Rezoning Transportation Analysis

Petition Number: Zoning Petition #2021-019

Date	Description
02-25-2021	First Review (KP)
08-23-2021	Second Review (KP)
09-17-2021	Third Review (KP)

REZONING SITE PLAN SCALE 1" = 60'

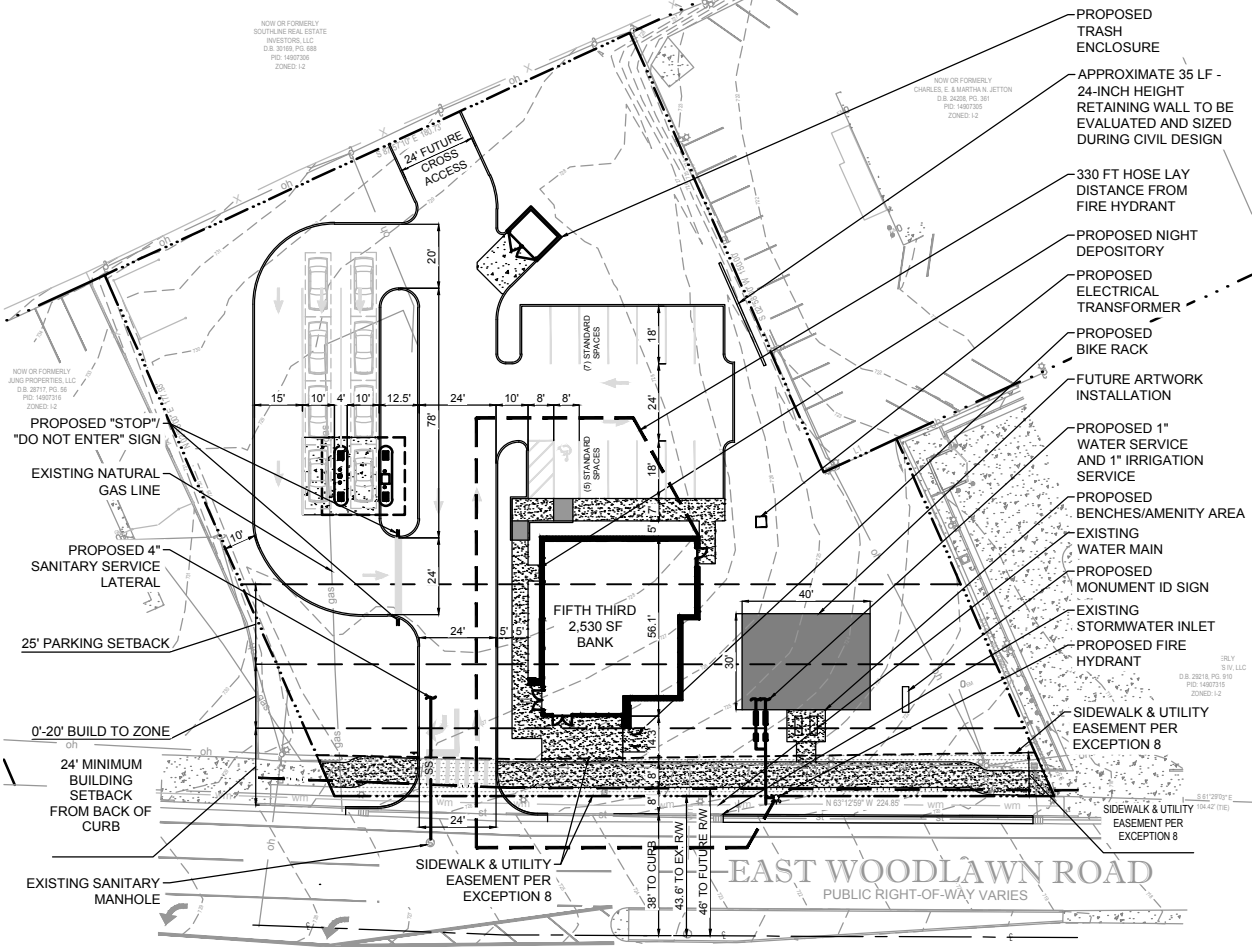
2. ~~Including a conditional note that the proposed site access, off Woodlawn Road, will be subject to NCDOT recommendations and approval, to be coordinated during the permitting process.~~

3. ~~A site plan note(s) specifying dedication and fee simple conveyance of all rights-of way to the City and/or NCDOT before the site's first building certificate of occupancy is issued is needed. CDOT requests rights-of way set at 2' behind back of sidewalk where feasible.~~

4. ~~A site plan note specifying that all transportation improvements will be approved and constructed before the site's first building certificate of occupancy is issued is needed. The petitioner may phase transportation improvements if said improvements and phasing are explicitly described in site plan notes.~~

5. ~~Revise the conditional notes by including the following note:~~
